An
Coimisiún
Pleanála

Memorandum:

Re: ABP Ref. No. ABP-310461-21

Development: Application for Substitute Consent for Quarry

STORAGE/DRYING SHED DETAILS

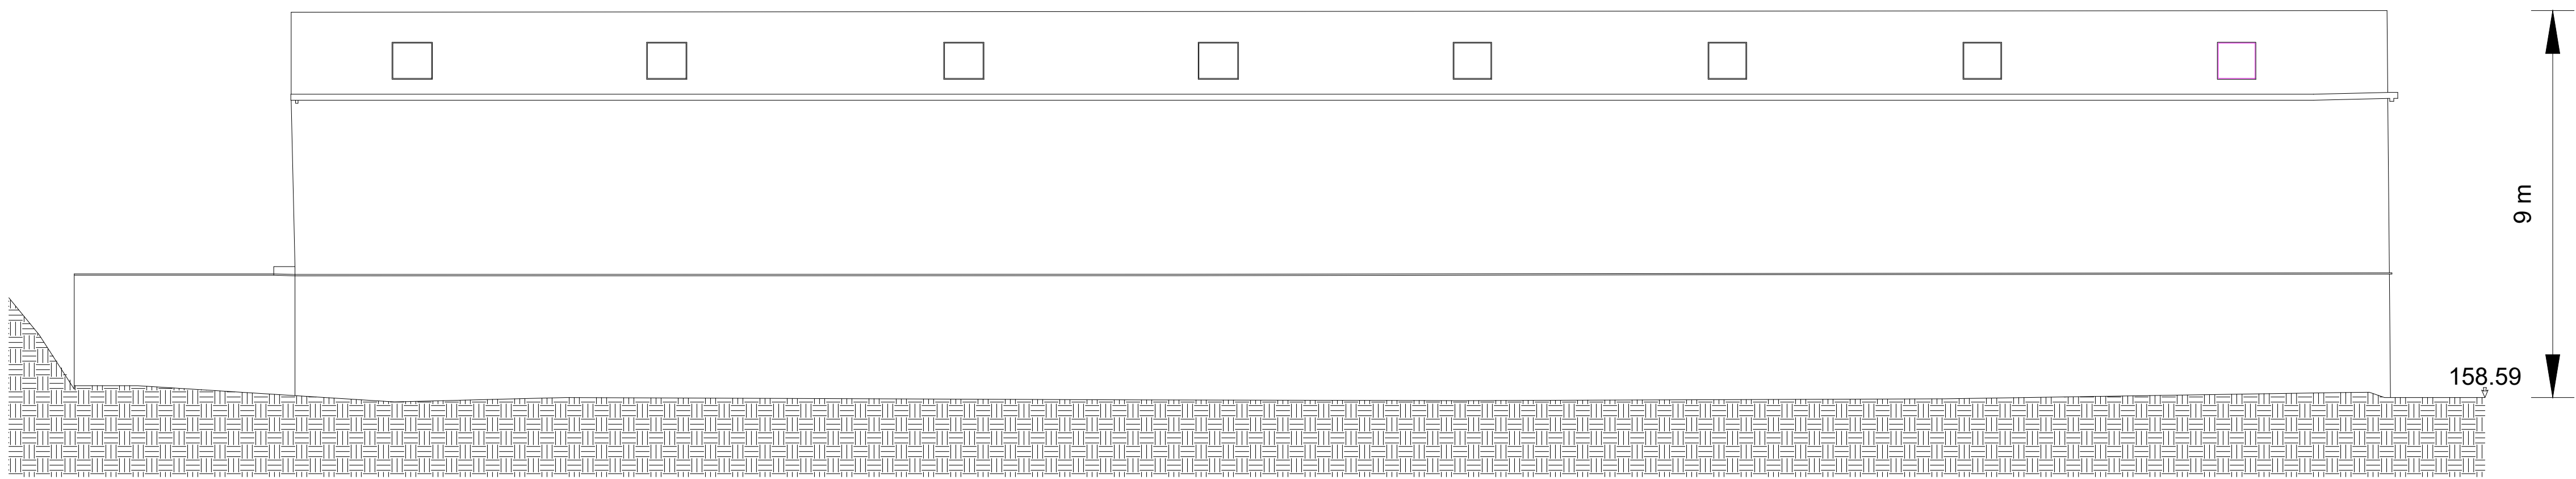
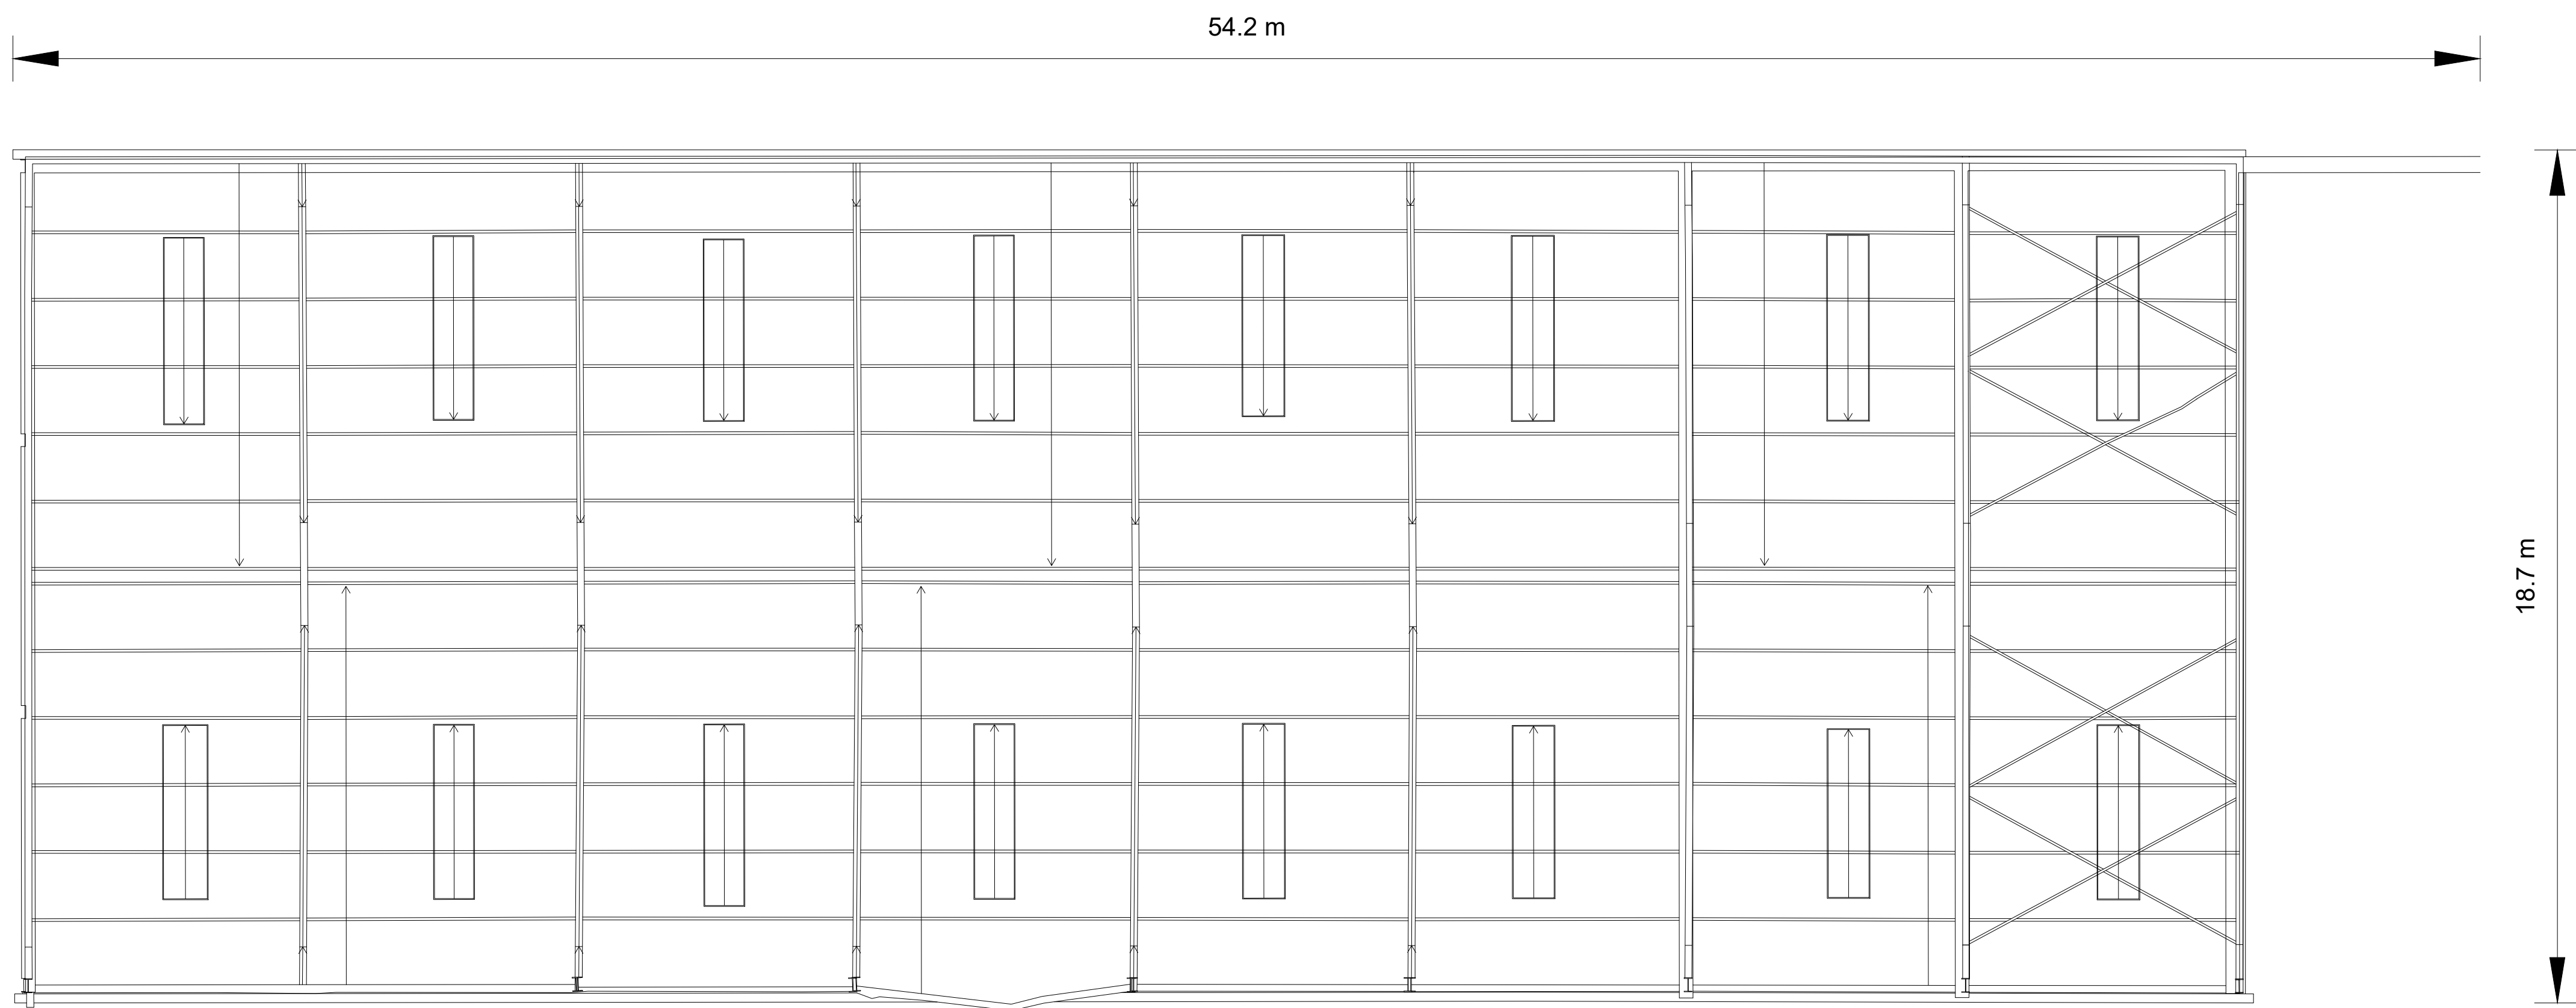
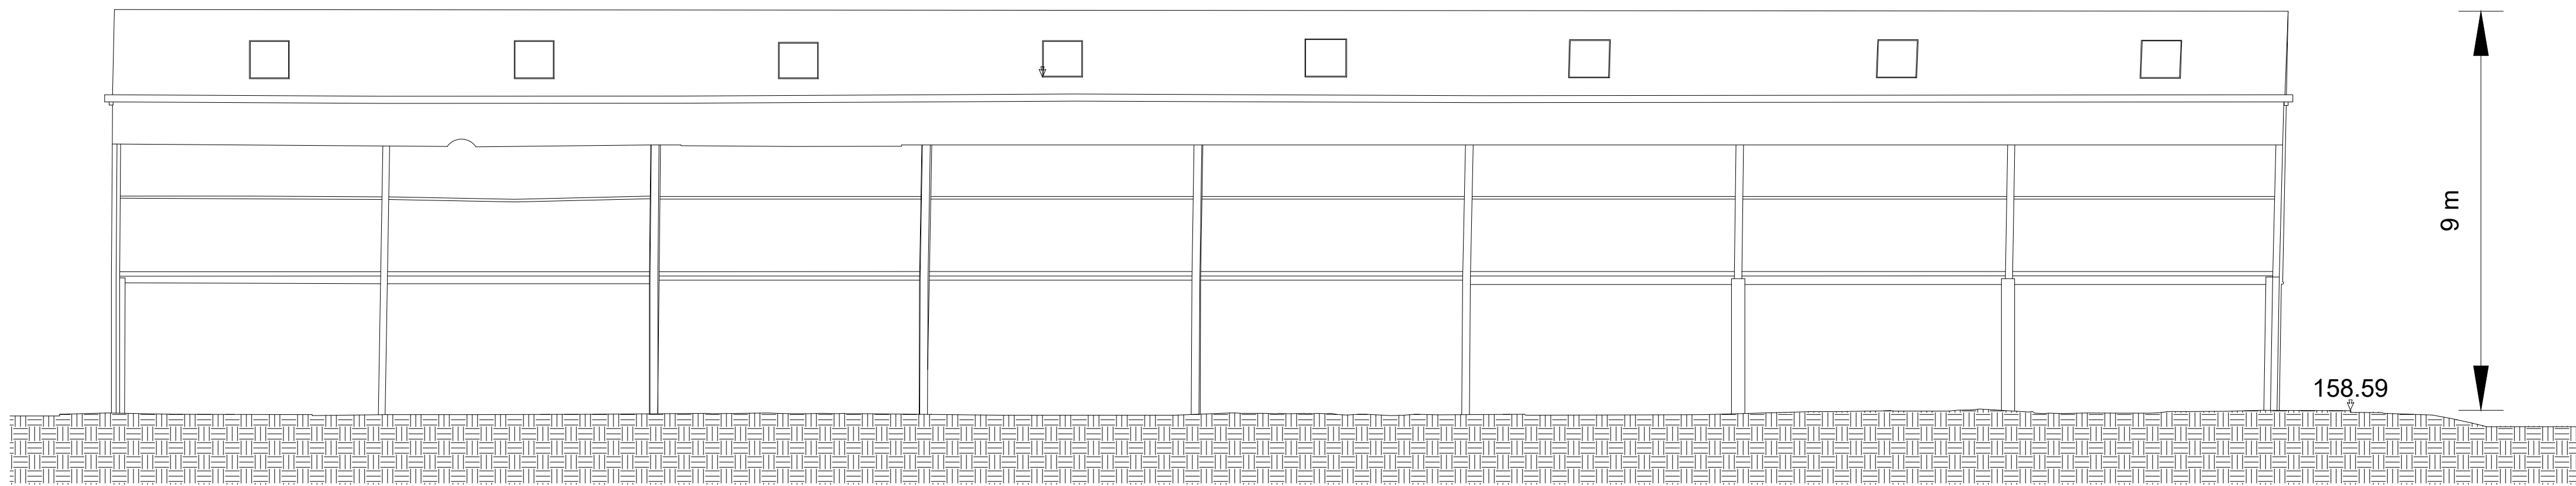
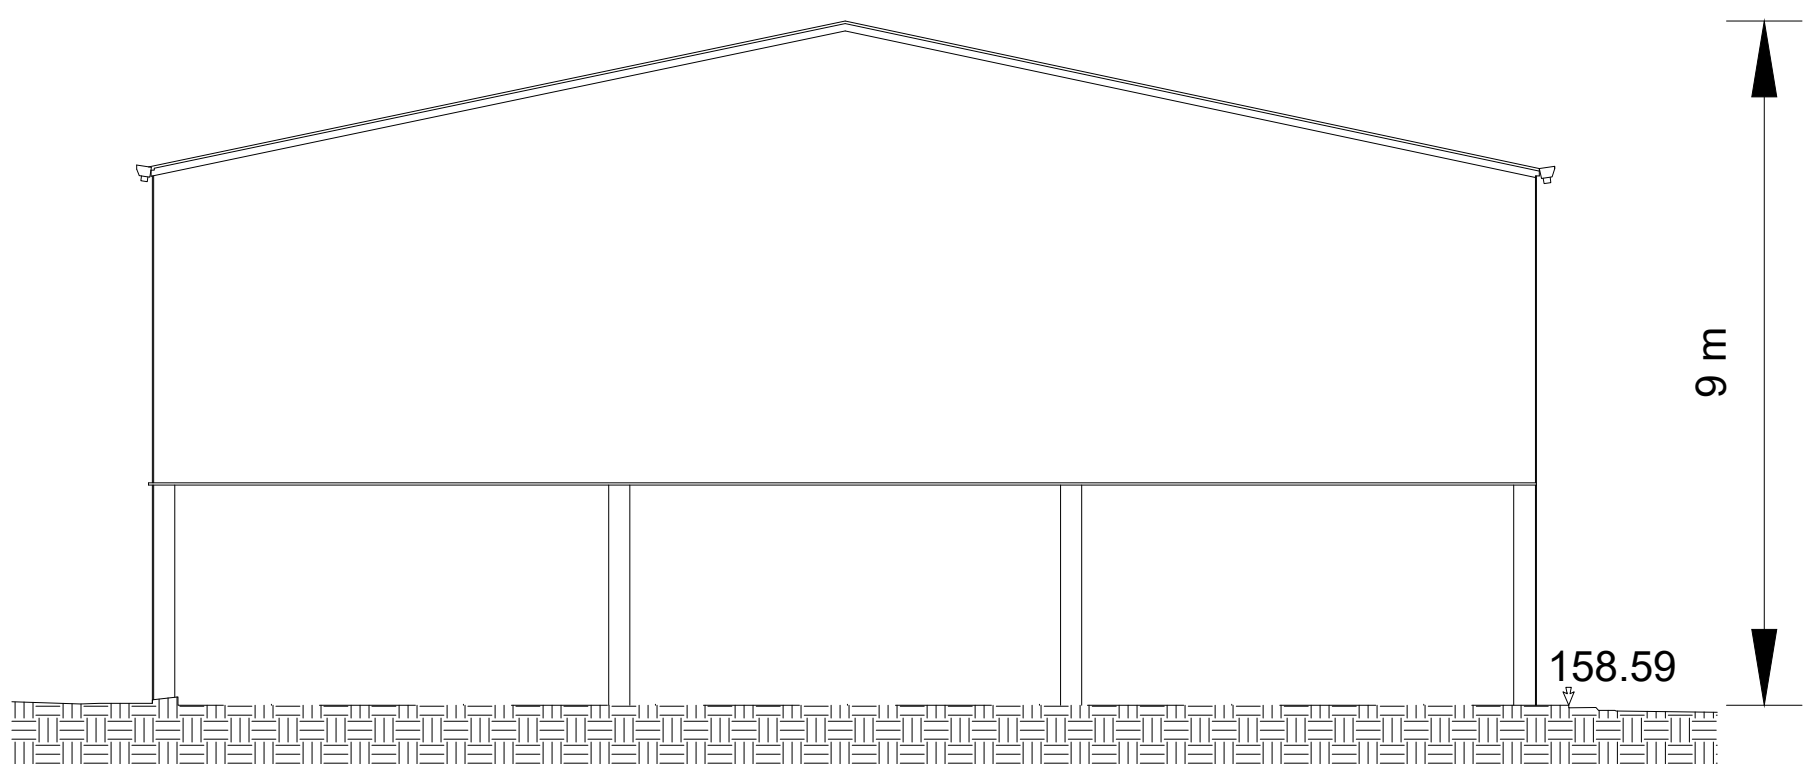
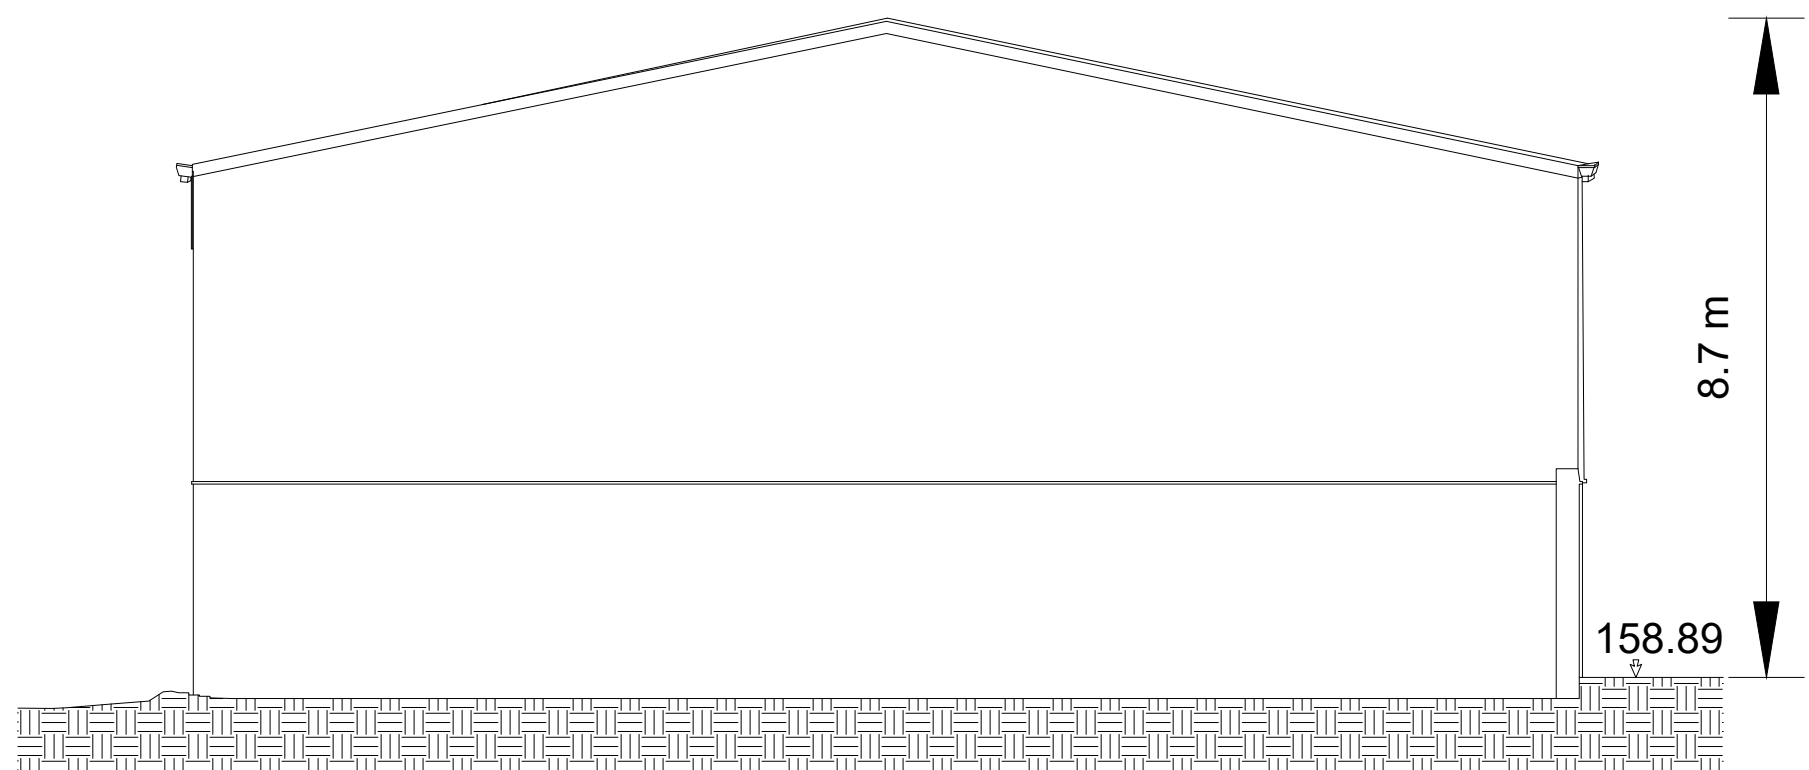
Within the administration and plant processing area of the wider quarrying operation there is an existing structure identified as a 'storage / drying shed' on the site layout plan (Drg. No 04b: 'Existing Site layout – Plant Area') which has been described as accommodating the storage / drying of processed aggregate products. In this regard, it is of relevance to note that the cover letter submitted in support of ABP Ref. No. ABP-310461-24 states that this structure does not benefit from either pre-1963 or exempted development status and has been found to fall outside of the definition of a quarry under the Planning and Development Act, 2000, as amended. Accordingly, the shed has not been included in the application for Substitute Consent with the applicant's stated intention being to pursue a separate regulating planning consent route for the structure after seeking the opinion of the local planning authority. Notably, consideration of this existing shed has been included in the Remedial Environmental Impact Assessment Report undertaken for the subject application.

Contrary to the assertions made in the planning application, following a review of the available information, and having undertaken a site inspection, it can be confirmed that the structure in question is presently operating as a packaging provider (trading as 'Just Packaging Ltd') and thus is being used for purposes unrelated to the quarrying operation. In this respect, both the structure and its use constitute development requiring regularisation and have not been considered in the submitted Remedial EIAR for the subject application.
